My Ref: 2023/0753 & 2024/ENQ/00464
Your Ref:
Date: 21/01/2025
Enquiries Elaine Ward
Direct Dial: 01226 774731
E-Mail: elaineward@barnsley.gov.uk

APPLICATION FOR NON-MATERIAL AMENDMENT

Description: Non- material amendment to planning permission 2023/0753 (Proposed Community Sports Facility including single storey multi use building, all weather sports pitch with floodlights, two no. temporary storage containers and associated car parking and landscaping) to relocate the sports pitch 4m southeast and realignment of overspill car park

Land to the east of Sheffield Road, Hoyland, Barnsley

TITLE
Combined External Light Spill Plans

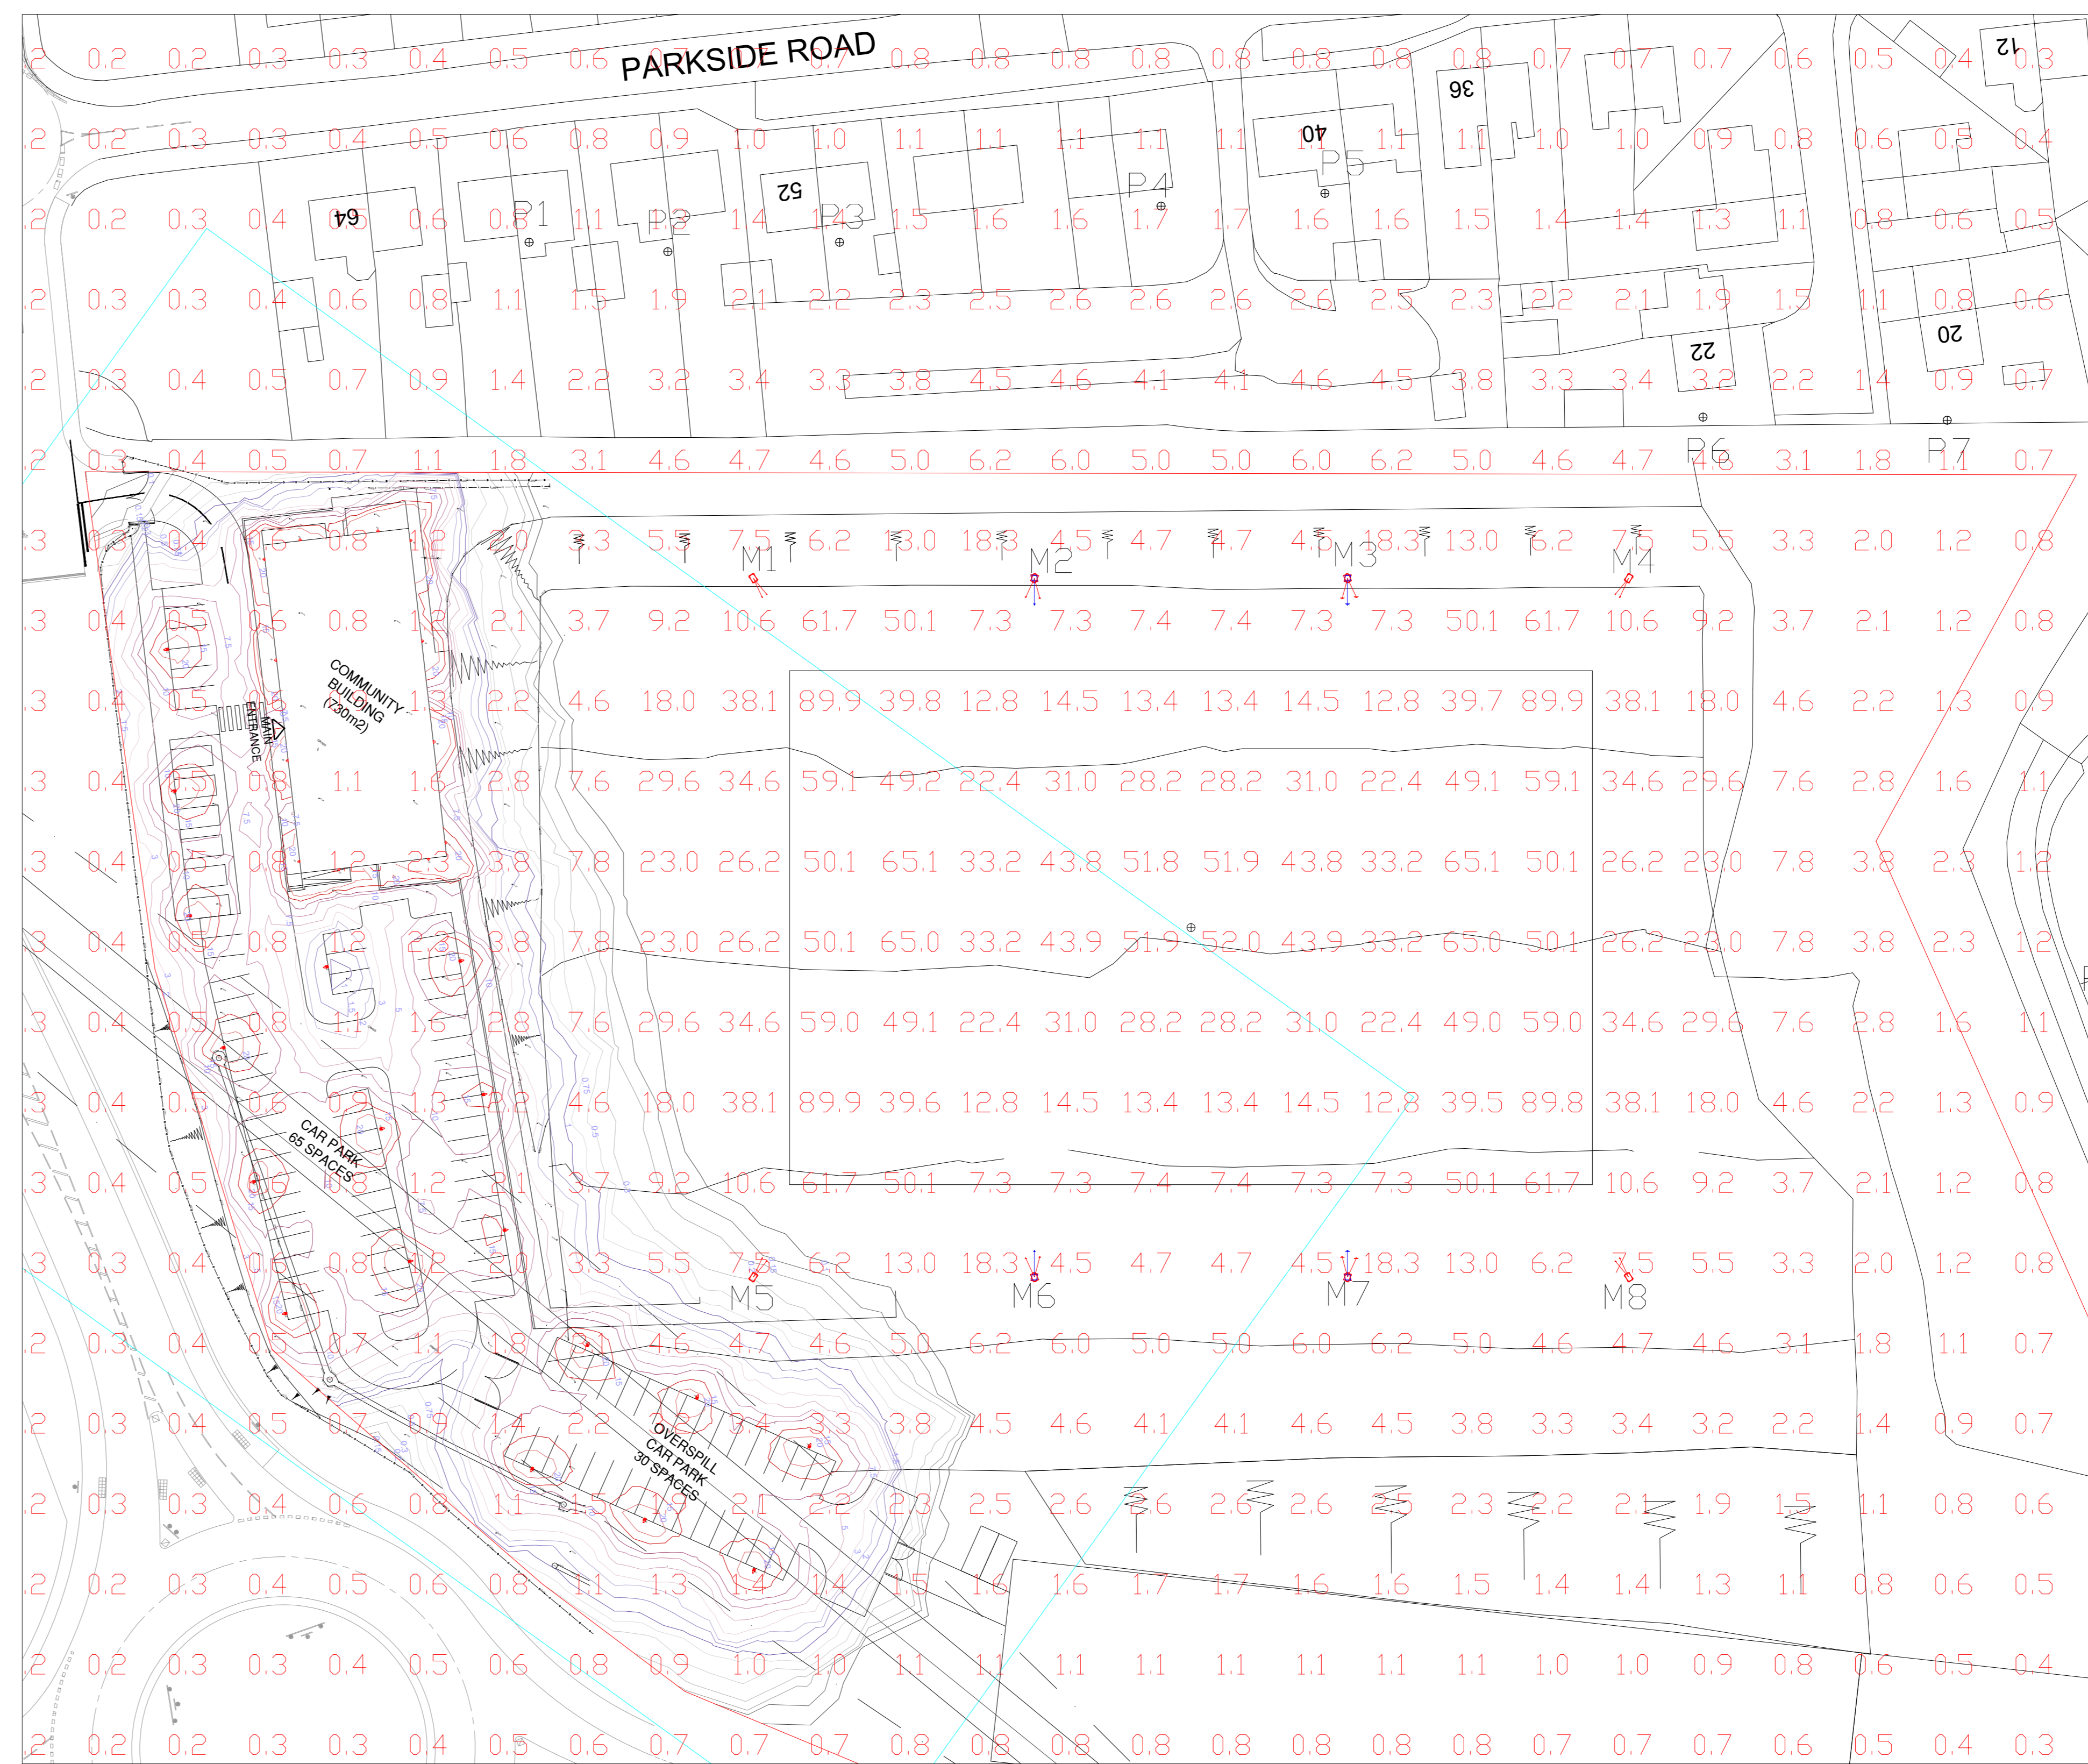
The effect of moving the pitch (and associated acoustic fence)south would also have the benefit of being located further away from dwellings to the so potential noise and lightspill to these properties would be reduced as a result.

A-DR-P02-site plan P7
A-DR-P04-site sections P5
A-DR-P08-Pitch fencing P5
027-211 Proposed combined landscape plan
A-DR-P09 REV P3 Combined External Light Spill Plans

TITLE  
**Proposed Site Layout**

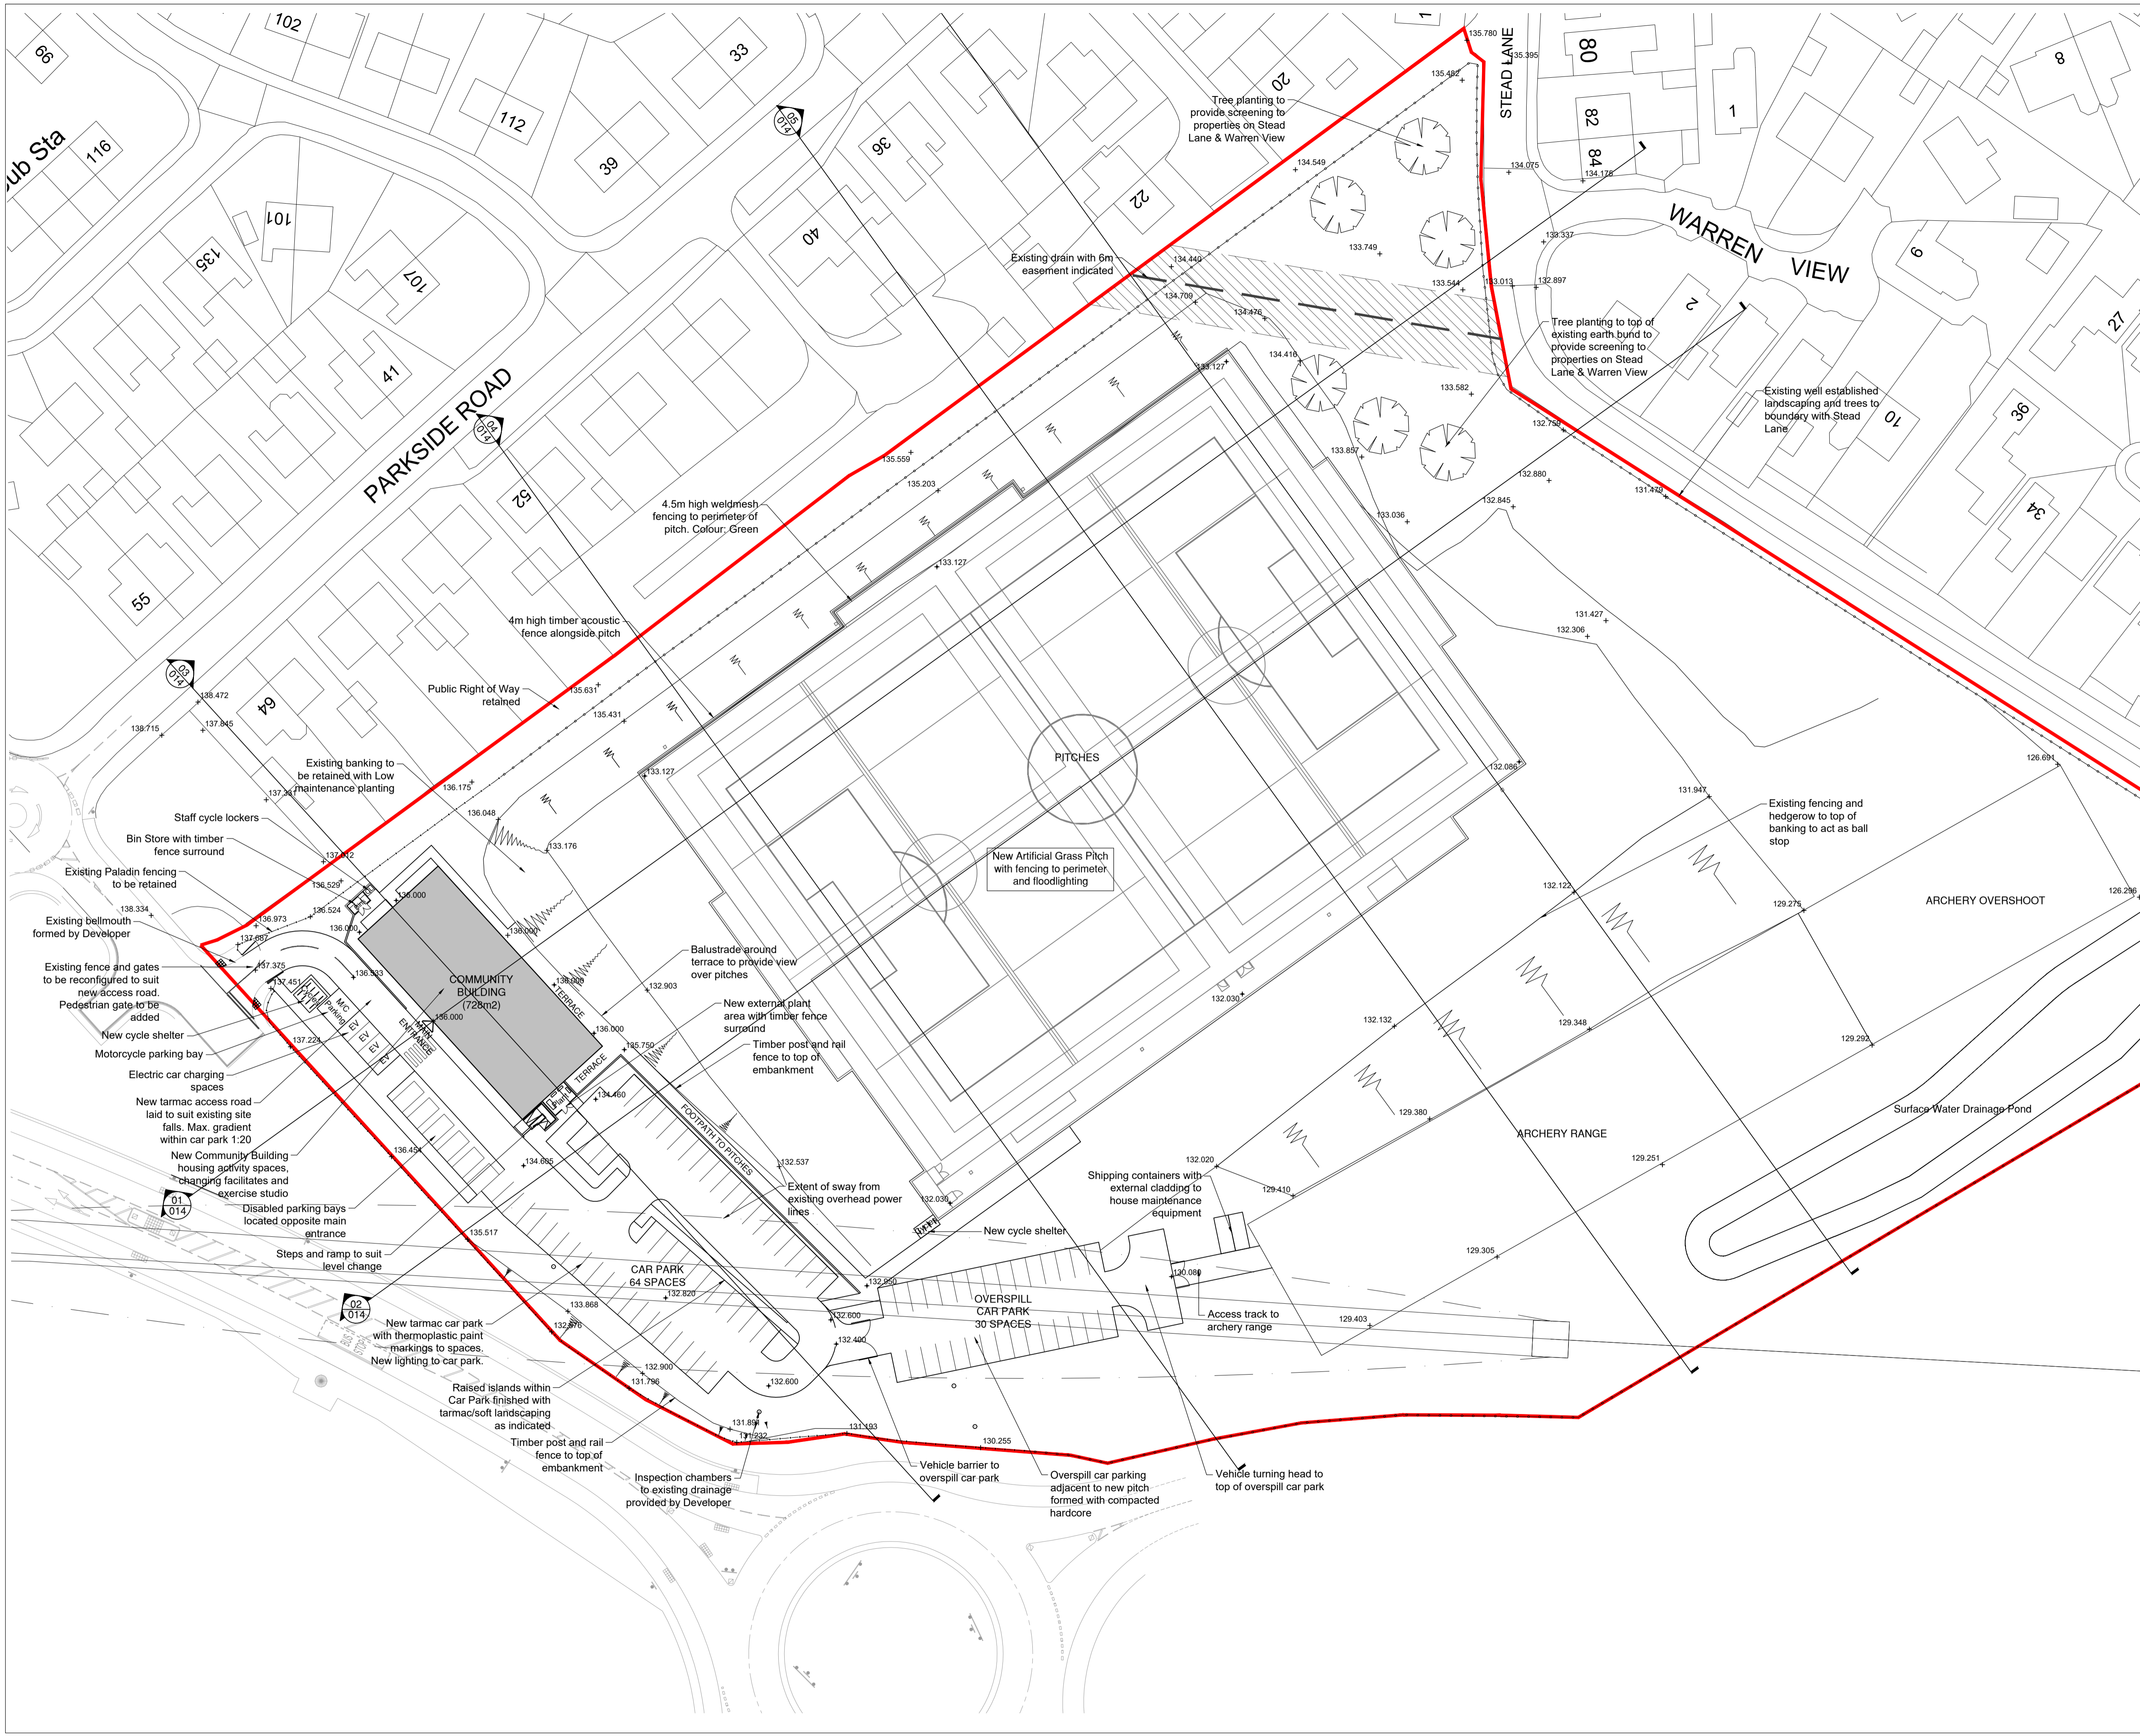
1. Relocation of the sports pitch in a southerly direction
2. Realignment of overspill car park

The effect of constructing the pitch 4m to the south however, would require a slight realignment of the overspill car park and a minor adjustment to the path to the south. It would not however, result in the loss of any car parking spaces or changes to the access from Sheffield Road. Nor would it result in vehicles being brought closer to any existing residential properties.
